City of Albuquerque Stormwater Construction Site Inspection Report

ESC File No.	H10E033	Project Name:	2200 Vista Oriente
NPDES Id. No.	NMR10036M/NMR10060F	Location:	2200 Vista Oriente
11/8/2023	Owner	Contractor	
Operator	Tuan Huynh		
Contact name & title	Tuan Huynh		
e-mail	tuanvnhm@yahoo.com		
Contact Phone #	505-269-1418		
COA Inspector	Chancellor English	Start/End Time:	9am
Construction Phase:	none, weeds and partial land disturbance		
Type of Inspection:	<input checked="" type="checkbox"/> Regular	<input type="checkbox"/> Storm Event	<input type="checkbox"/> Post Storm Event >0.25" <input type="checkbox"/> 311/Complaint <input type="checkbox"/> Follow Up
Weather at time of inspection?	Clear	Temperature: ~	65
Estimated date of last storm 0.25" or greater	9/14/2023

TEMPORARY EROSION AND SEDIMENT CONTROL PLAN

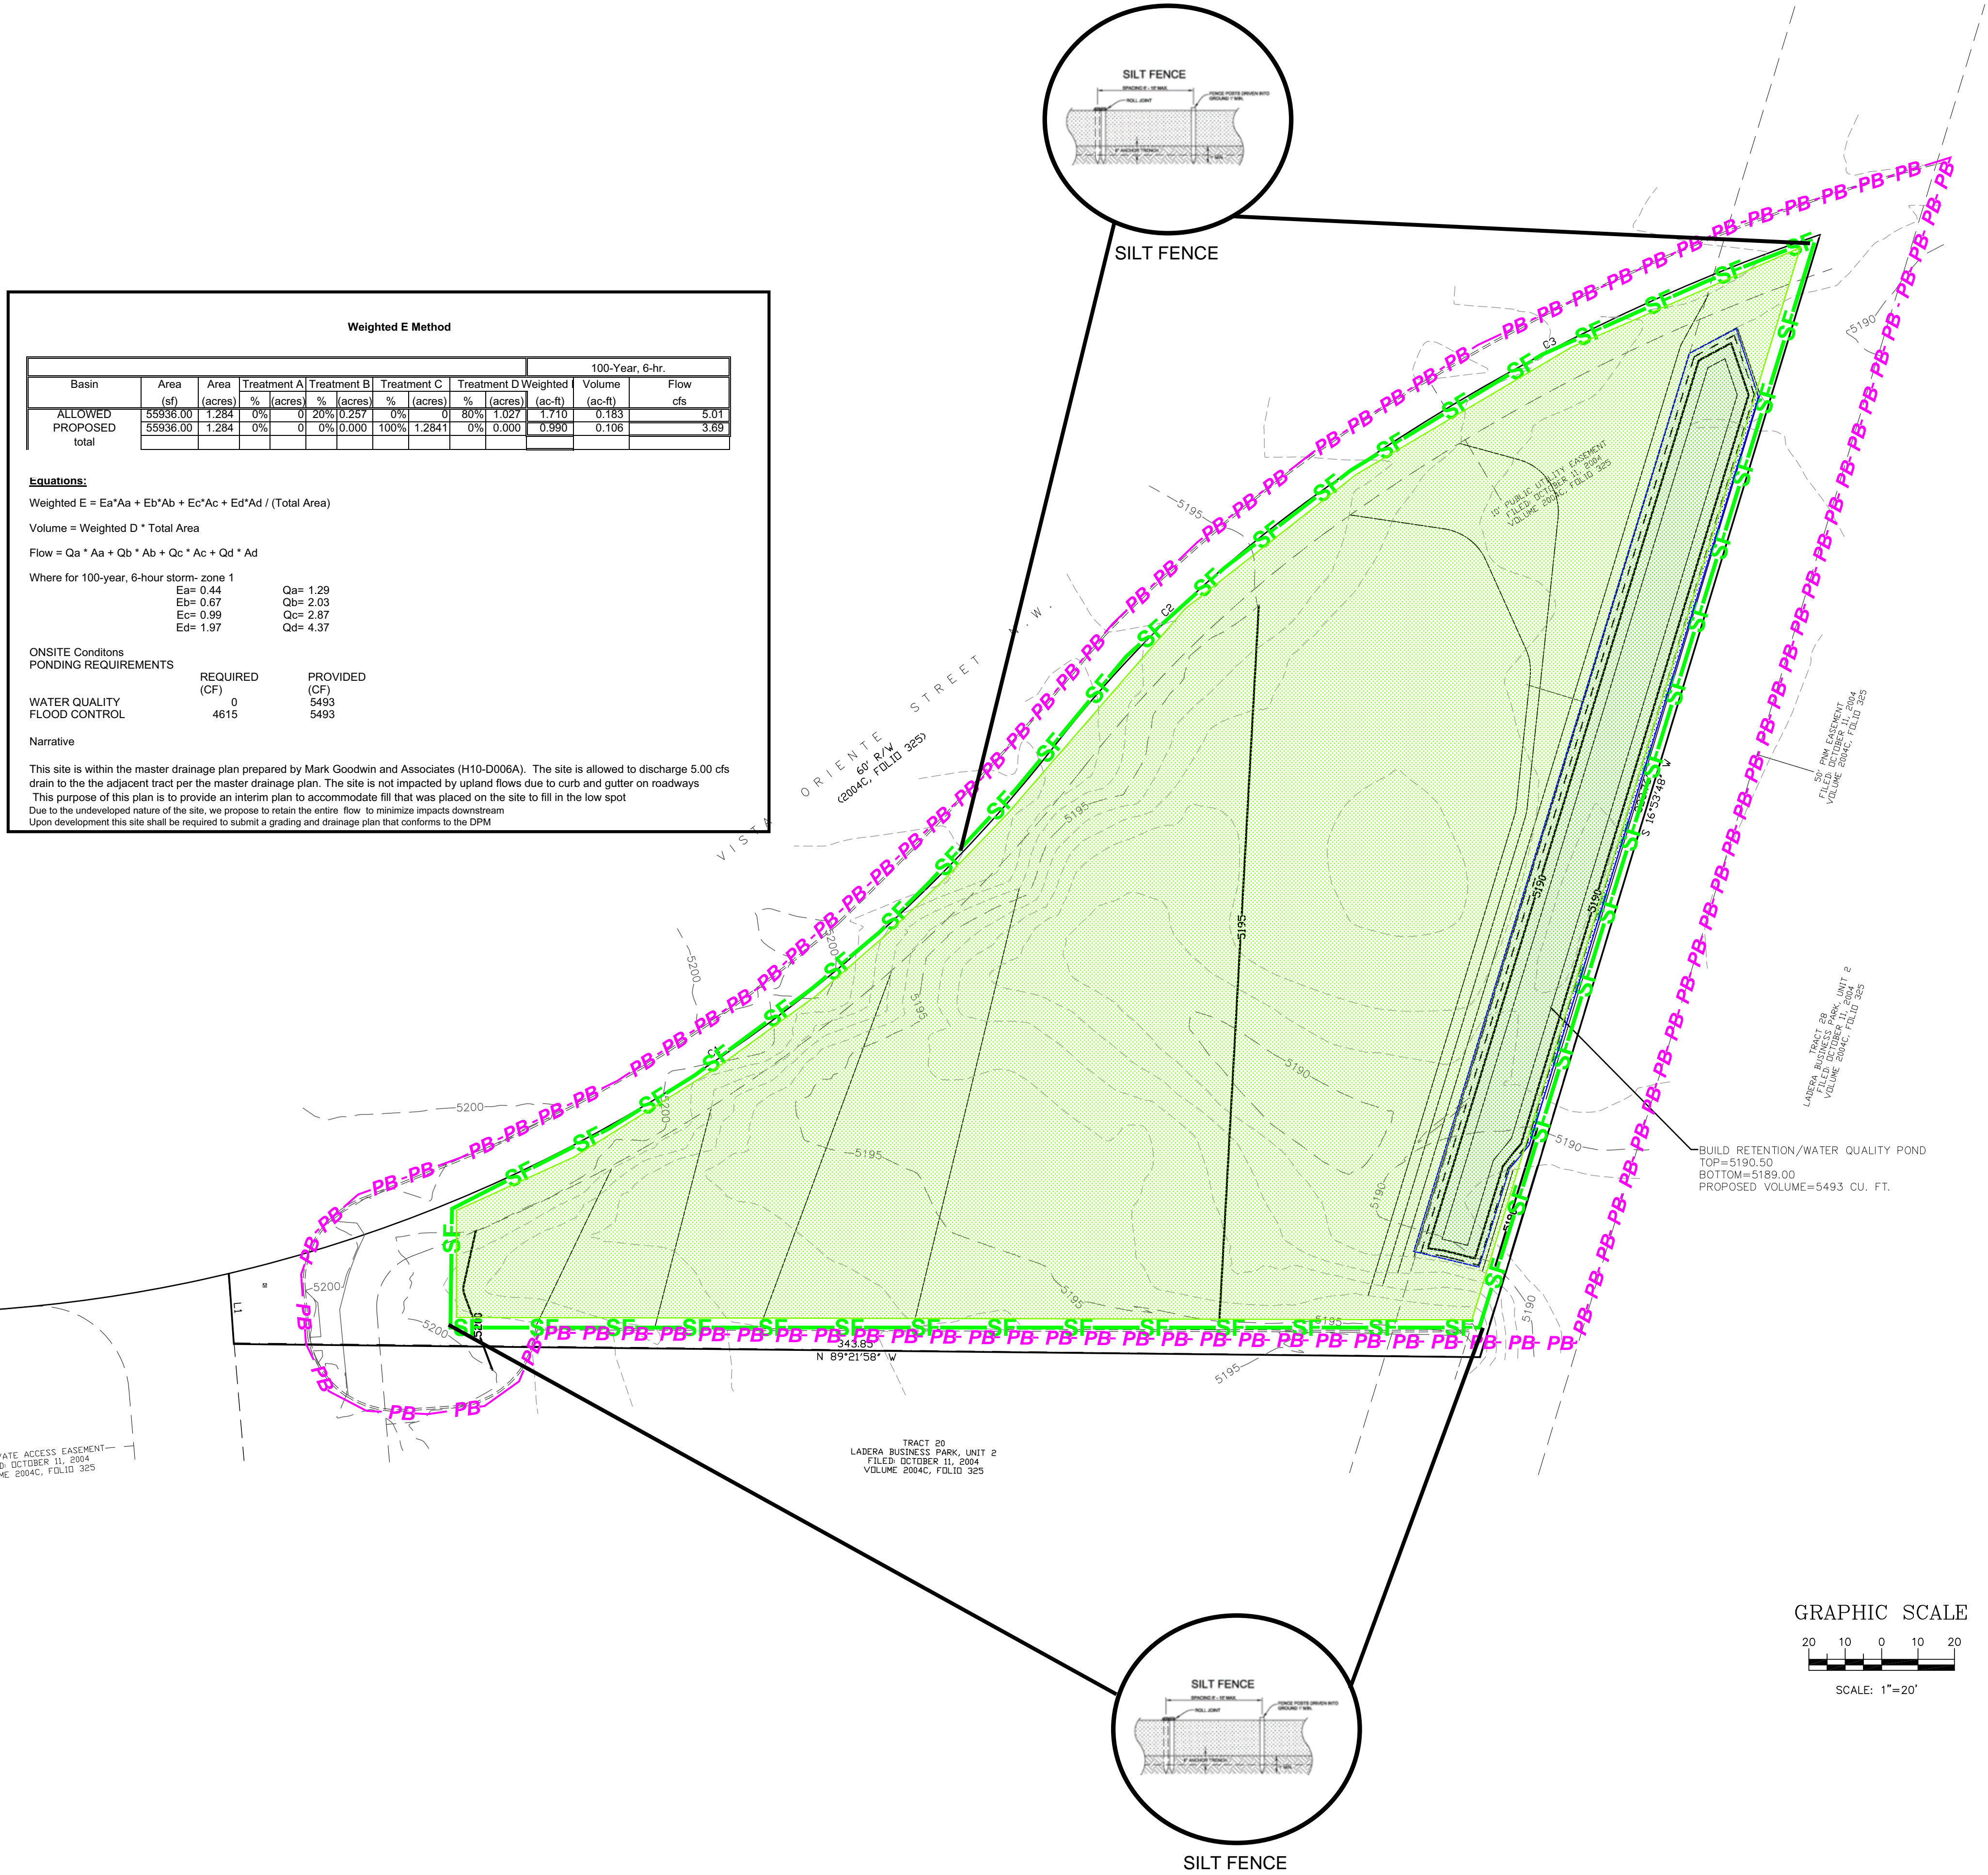
2	The site is still lacking compliant stabilization per CGP Part 2.2.14. The weeds are not sufficient vegetative cover and have become overgrown in violation of City Ordinance 9-8-4. The disturbed area needs stabilization. Required mitigation: Maintenance of weeds and stabilize the site if no construction activity for 14 or more calendar days as per CGP Part 2.2.14.

Notes:	Recent land disturbance on east side of site has been graded, but not stabilized
Prior violations for Posting, SWPPP, BMPs, and stabilization	
Weeds are becoming overgrown again and exceeding the 4" width and 4" height allowed by City Ordinance 9-8-4.
